**KIRKLEES METROPOLITAN COUNCIL  
INVESTMENT & REGENERATION SERVICE**

Reference No:	<b>2024/44/90602/W</b>
Site Address:	Bryan Wood Residential Home, 1, Bryan Road, Edgerton, Huddersfield, HD2 2AL
Description:	Discharge conditions 3 (boundary fencing), 5 (cycle storage), 7 (Arboricultural Method Statement), 11 (bat and bird box) on previous permission 2022/92581 for change of use from residential care home (Class C2) to a school (Class F1(a)) (within a Conservation Area)
Recommending Officer:	Lucy Taylor

**DECISION – APPROVE DISCHARGE OF CONDITIONS**

## **Bryan Wood Residential Home, 1, Bryan Road, Edgerton, Huddersfield, HD2 2AL**

DWG No: 1.0

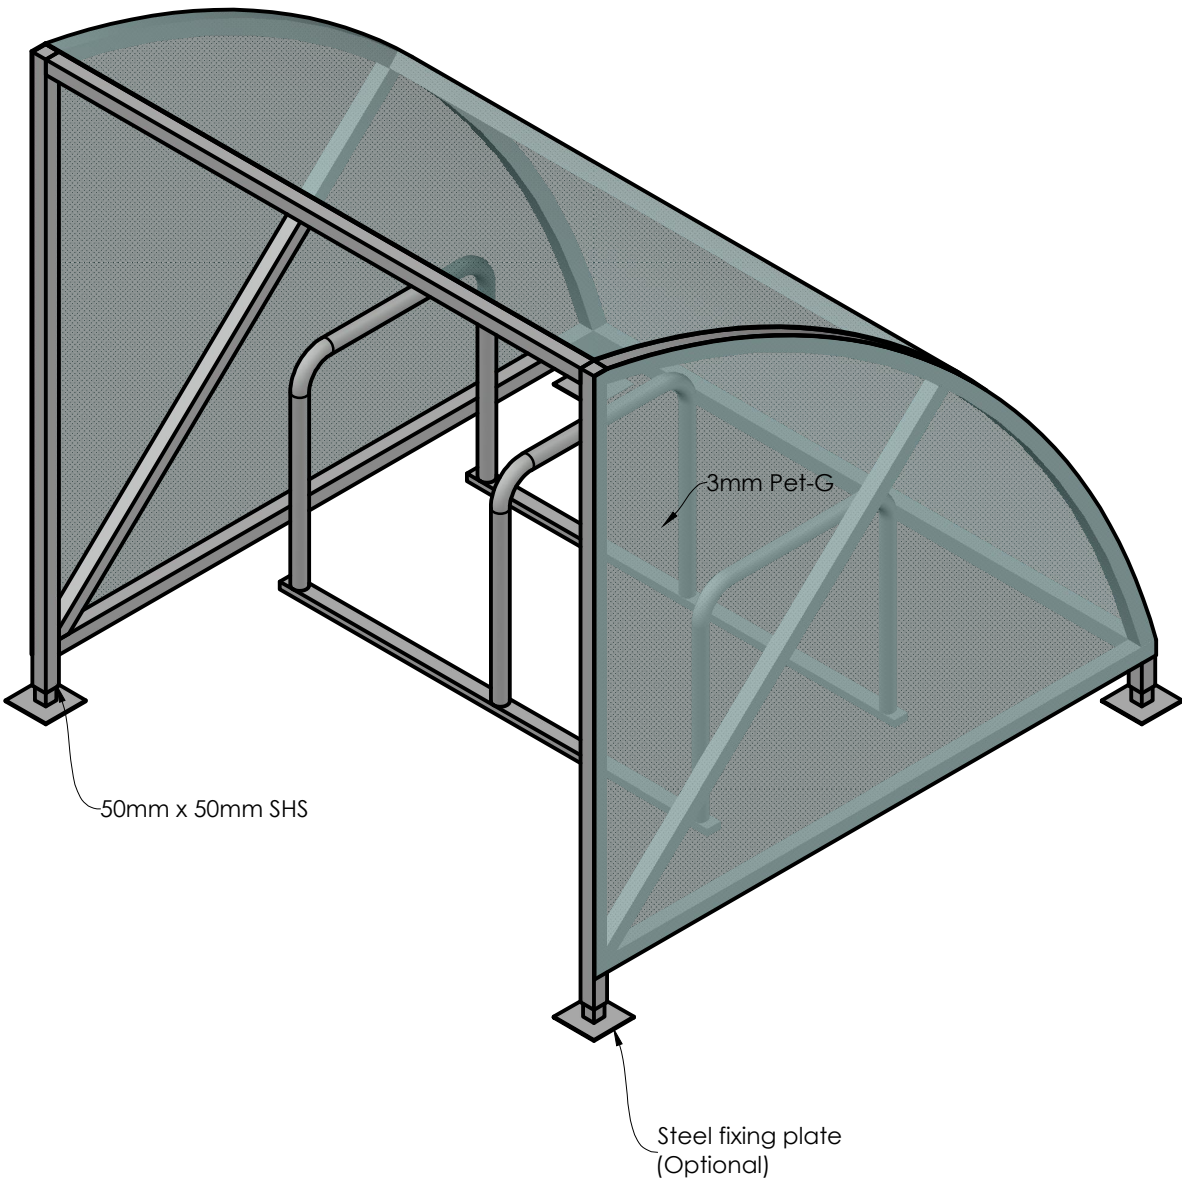
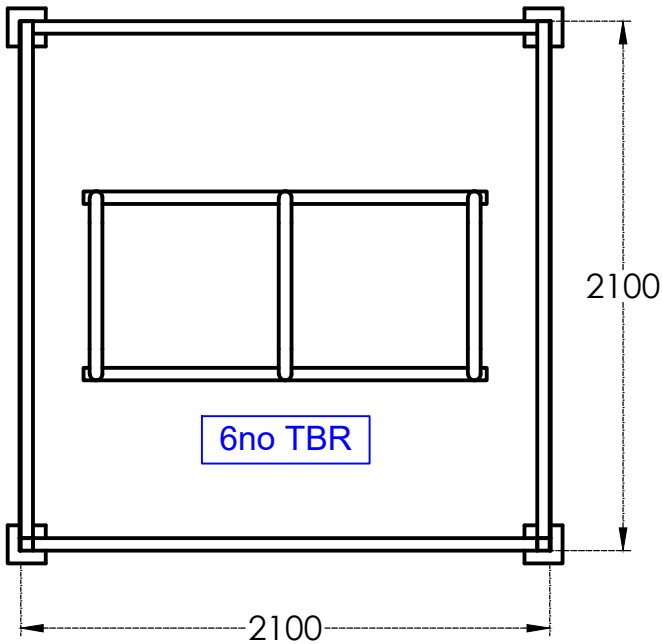
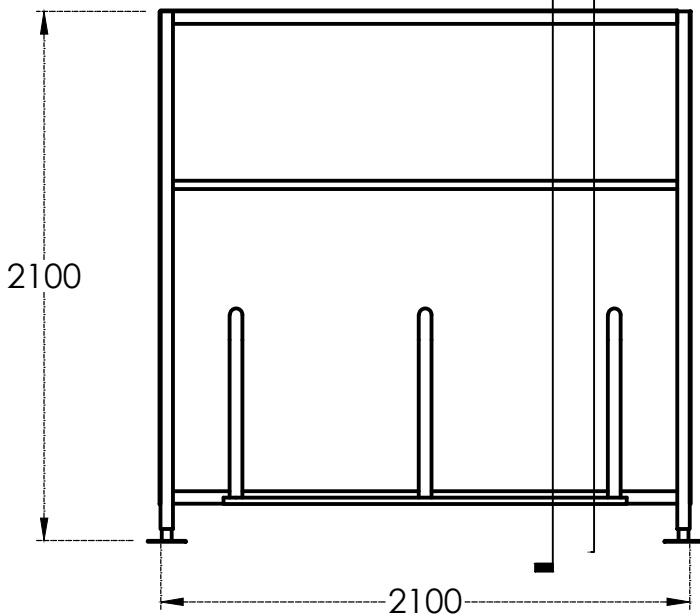
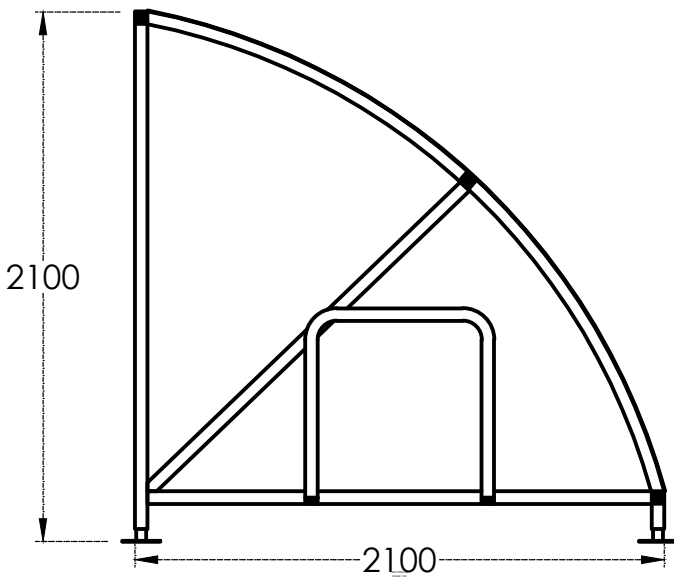
Drawing no 23-025-15 shows the location of the proposed cycle shelter within the site and drawing No. 1.0 shows the dimensions and design of the cycle shelter.

KC Highways Development Management were formally consulted on this application. They concluded that the plans identified a suitable location for the cycle shelter and that drawing No. 1.0 shows the type of shelter to be provided. KC Highways Development Management confirmed that they consider the drawing acceptable to discharge condition 5.

Therefore, based on this assessment, it is concluded that the information within drawing No. 23-025-15 and drawing No. 1.0 provides details to allow the discharge of condition 5, provided that the approved cycle storage is provided before the development is brought into use and is thereafter retained as such.

project: Bryan Wood
Huddersfield
client: Polaris Children's Services
drawing: Boundary treatment +
fences
drawing number: **23-025-15**
revision: A (06-06-24)
date: May 24
scale: 1:500
original size: A3
issue: Approval
drawn: DUJ
checked:

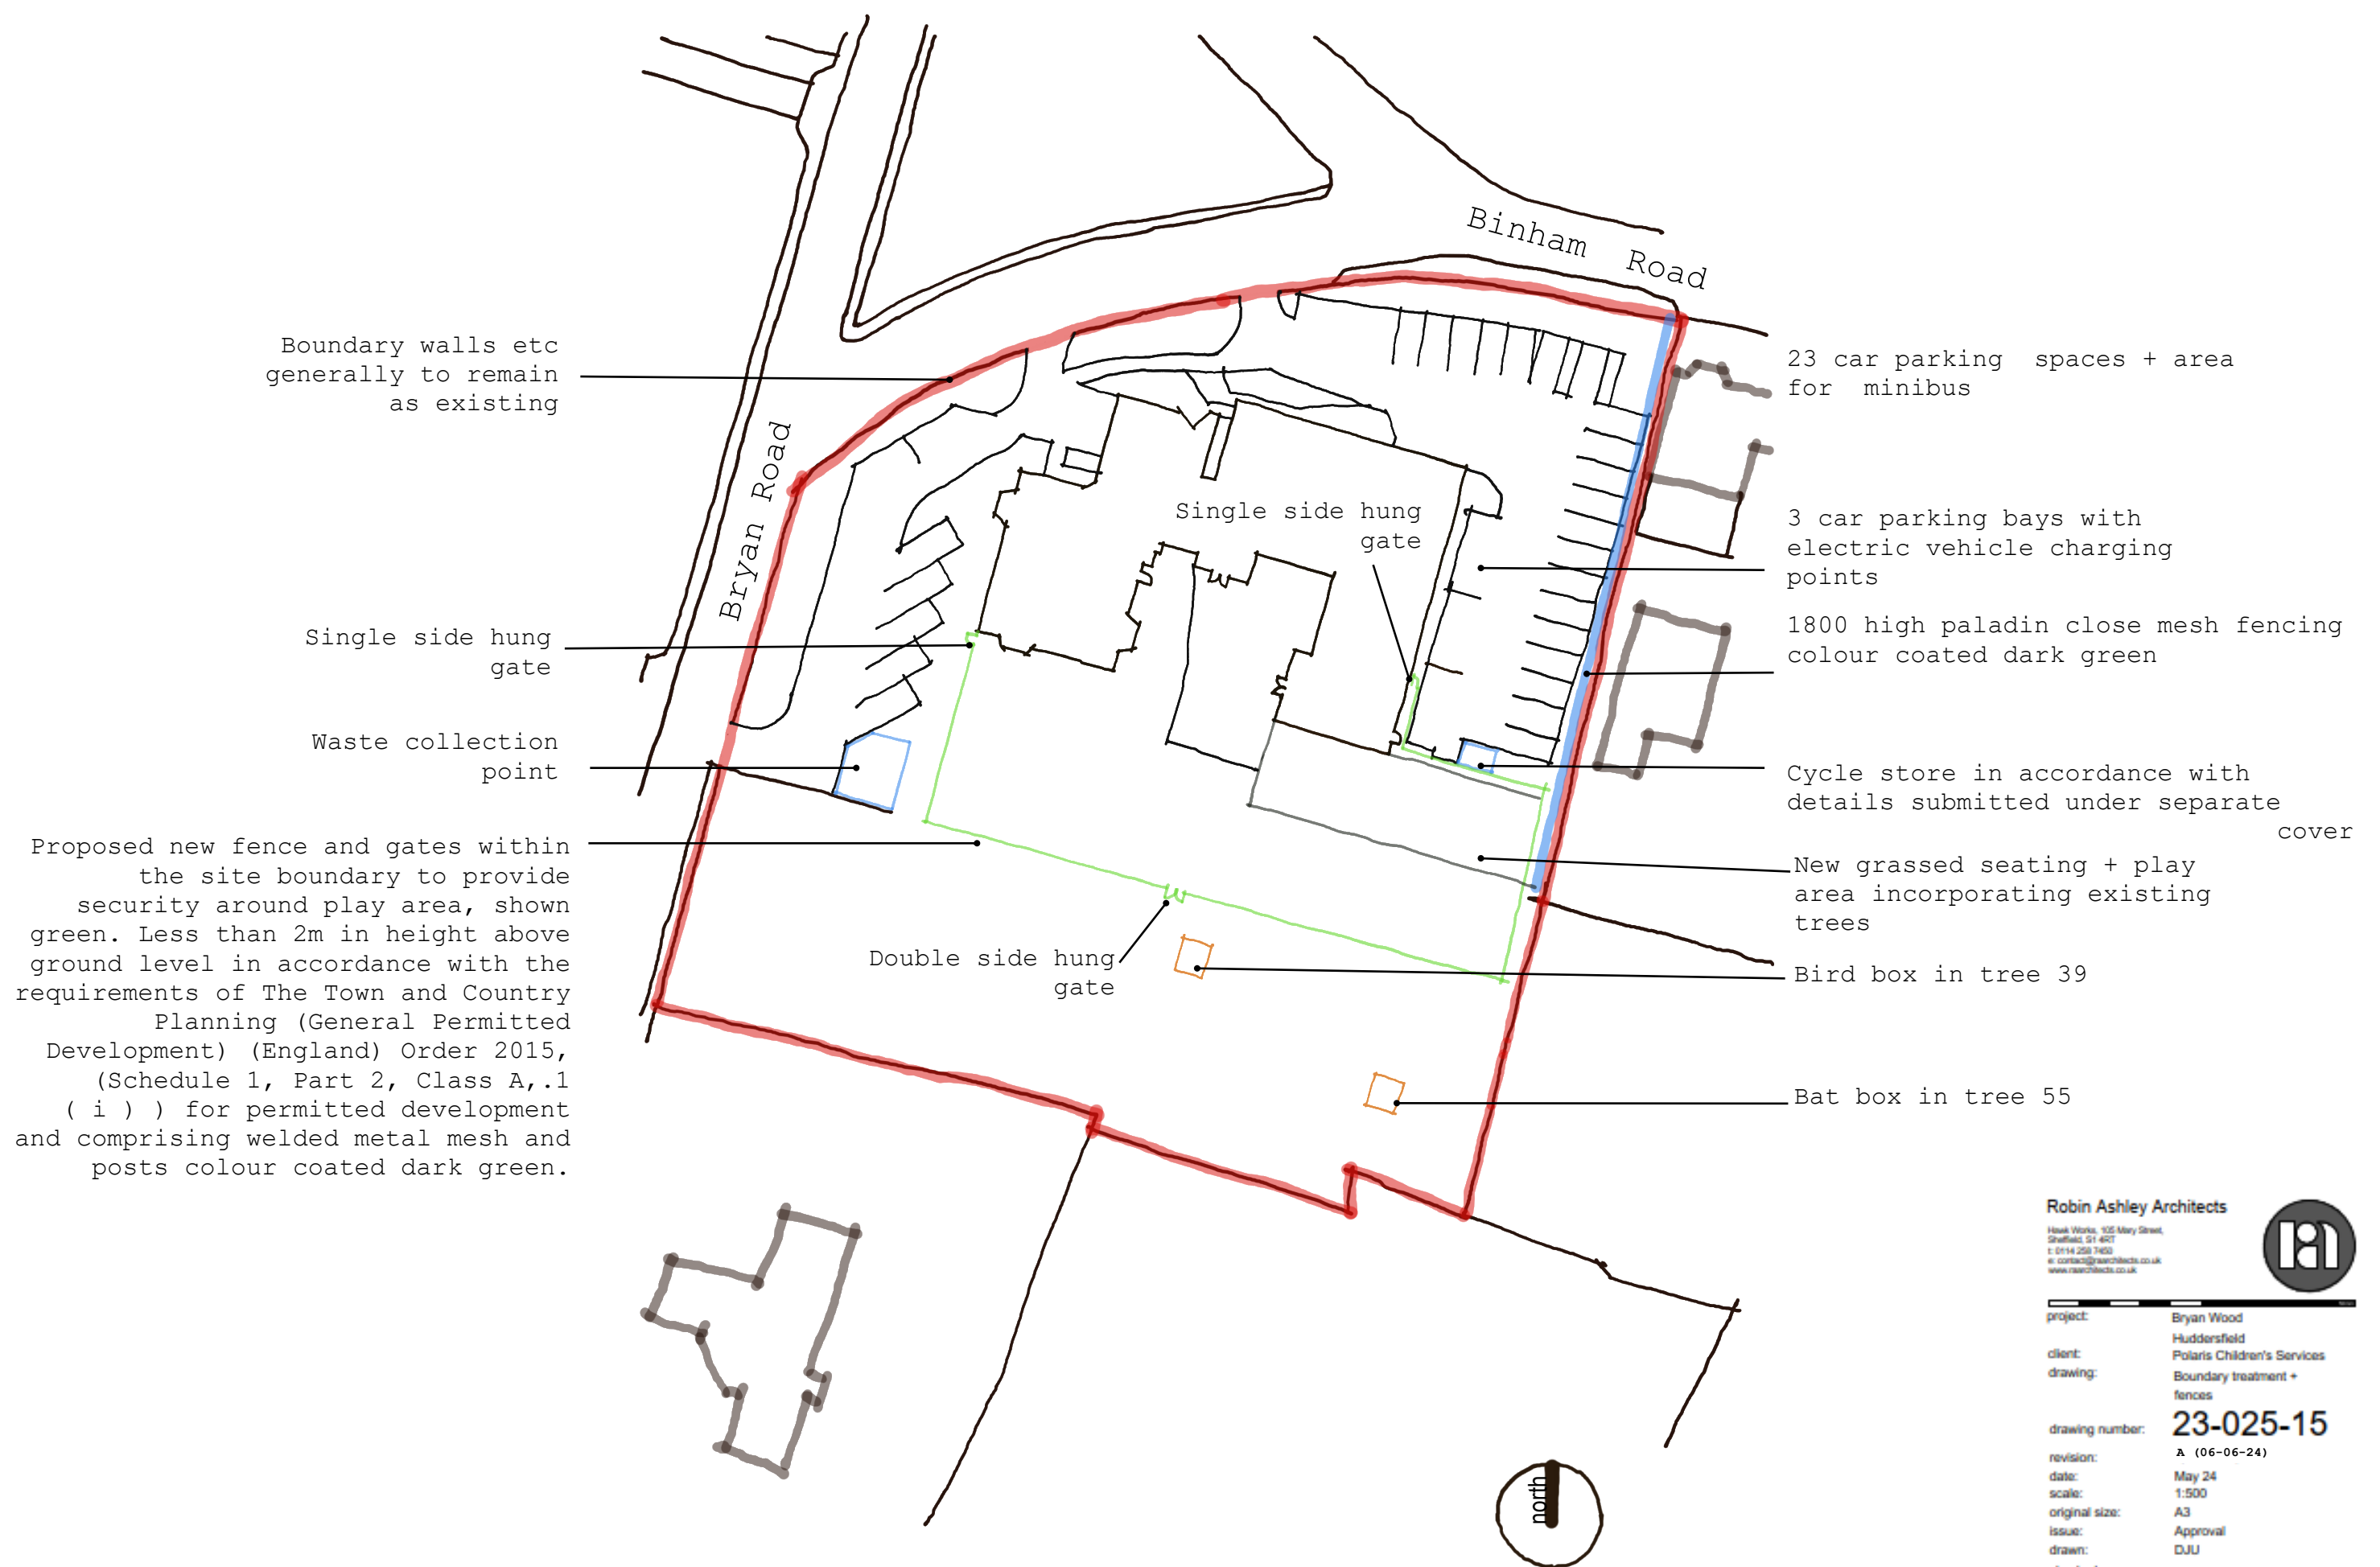
Drawing 23-025-15 confirms that the boundary walls at the site are to remain generally the same and that the proposed new fence and gates within the site would be less than 2m in height above ground level and would comprise welded metal mesh and posts, colour coated dark green.

KC Conservation and Design have been both formally and informally consulted on this application, concluding that the fences and boundary treatments as shown on drawing No. 23-025-15 are acceptable to discharge condition 3.

KC Crime Prevention were also formally and informally consulted on this application, with regards to the part of the condition relating to the safety of site users. KC Crime Prevention concluded that they consider drawing No. 23-025-15 to be acceptable.

Therefore, based on this assessment, it is considered that the information within drawing No. 23-025-15 provides details to allow the discharge of condition 3, provided the fencing is installed in full accordance with the approved details before the development is brought into use and thereafter retained as such.
